**RE: Submission by Way of Objection to the Proposed Modification 4
New CBD and South East Light Rail Project (the "Project")**
Our ref: [162/2015]

Foundation for Education and Training Limited (FFET) Submission for Proposed Modification 4 CDB and South East Light Rail Project

2) We object to the modifications of the existing approved project for the reconfiguration of the UNSW High Street stop design from one island platform to two separate platforms, either side of the light rail tracks

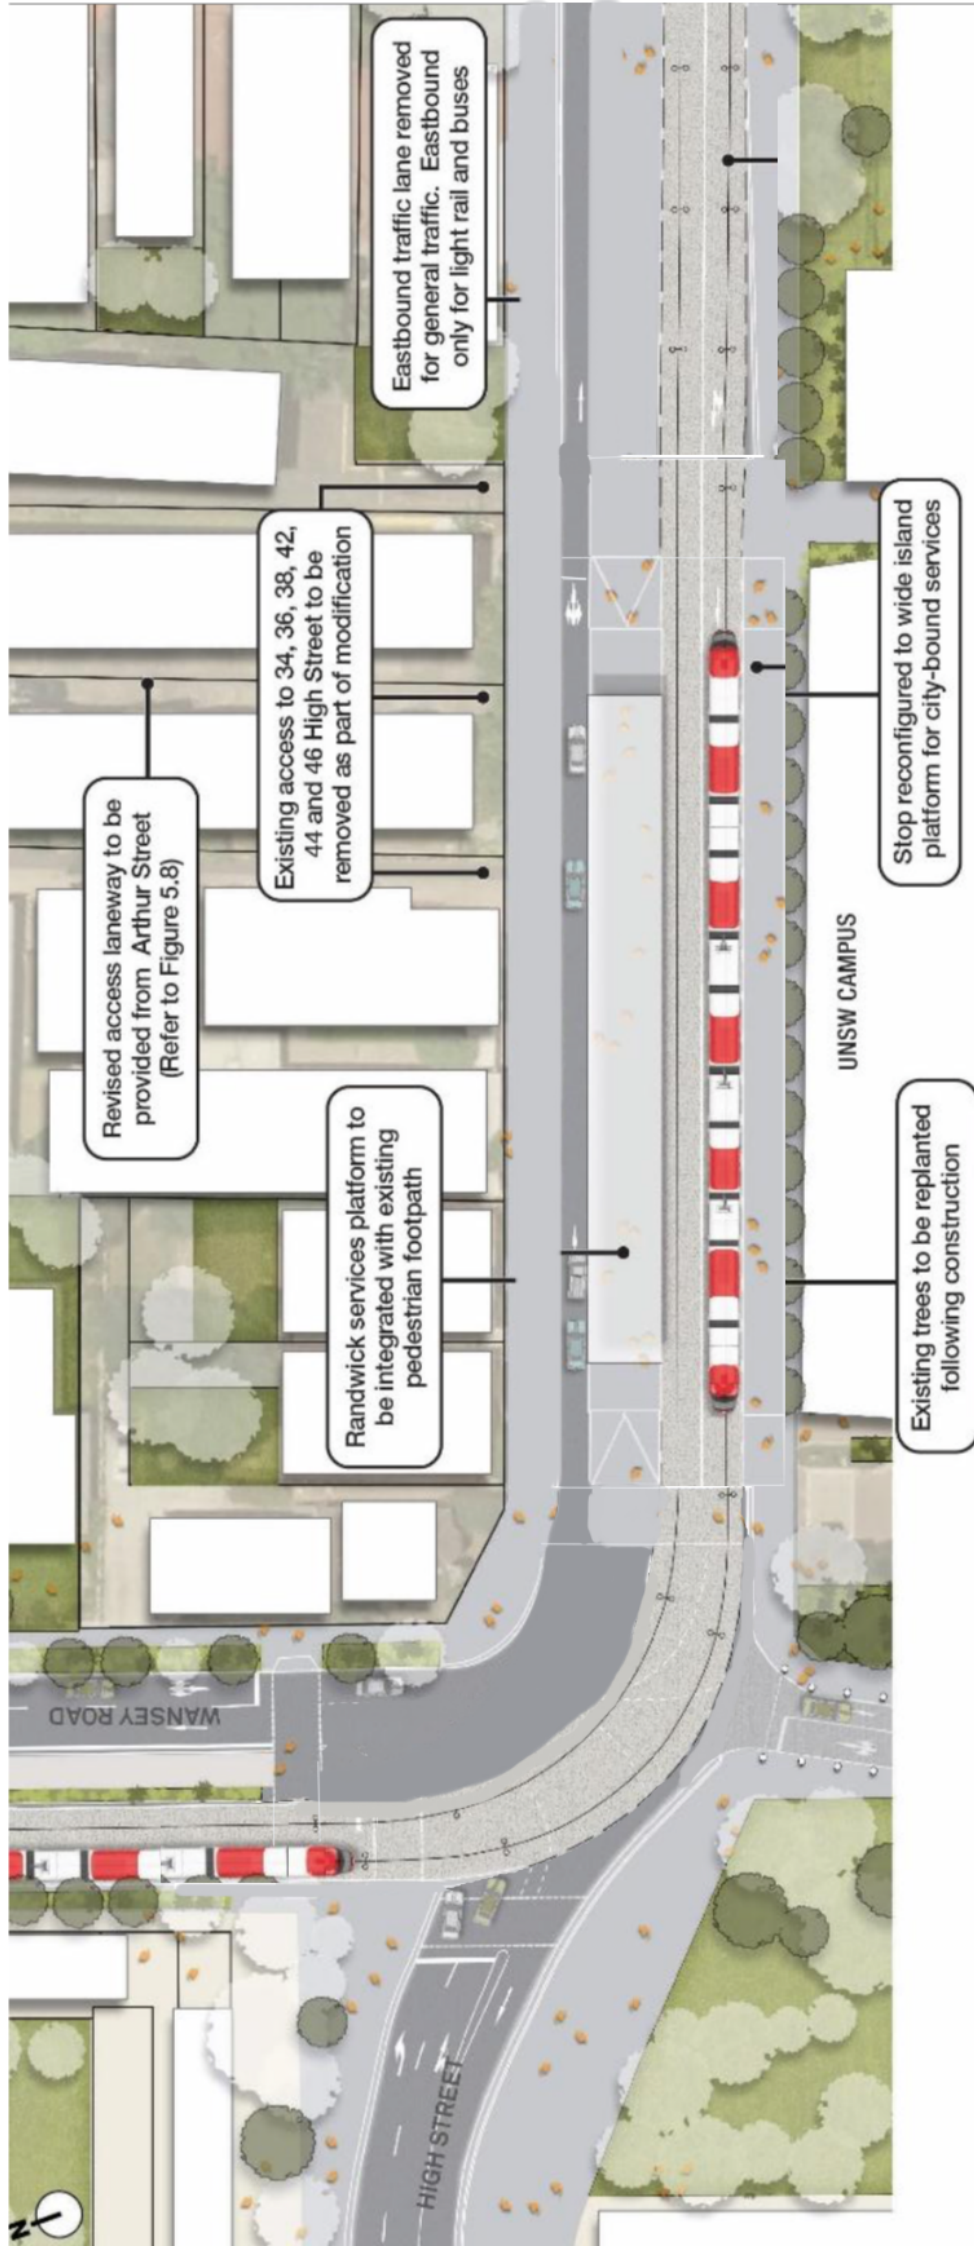
We dispute the changes to the existing project and disagree with the reconfiguration of the UNSW High Street stop arrangement.

The proposed design modification states that northern platform currently in front of Creston College and Kenvale College will be approximately 6 meters wide. We have real concerns about this lack of clarity and the word “approximately”. This is vague and can have serious implications. Light Rail is said to carry five times as many passengers as buses. There will be many more people alighting in front of our premises. In Peak periods approximately 400 people (maximum capacity 466 people) will be alighting a four carriage train. In our consultation meeting with NSW Transport on December 10, 2015 we were informed that the footpath will be 1.5 meters and the platform 3.5 meters, which only totals 5 meters. There are no calculations of the number of people that the road level platform will take before there is an overflow onto the footpath which blocks the entrances to our premises. NSW transport knows the trams will be arriving every 8 minutes they should have the data to calculate this impact.

The proposal is light on detail regarding the Arthur street lane. The current lane is a single vehicle lane. The written submission said that lane will be widened to approximately 6 meters (once again another vague statement) leading to a widened 'hammer head' area of approximately 8 metres wide along rear boundaries of the affected properties. We operate a commercial teaching kitchen on this property and we have daily delivery trucks from a range of suppliers. Currently we have a parking bay in front of 38 High Street for delivery vans and trades people. This parking bay will be lost in the proposal as it is close to the High Street and will be difficult to access. The proposal states that a new access lane will provide access to existing car parking spaces, however there was no consultation of the implication of this access. We have been given two entrances from Arthur Street lane into the property. We have studied the matter and at least four car park spaces will be lost from the back carpark and one car park space in front on High Street.
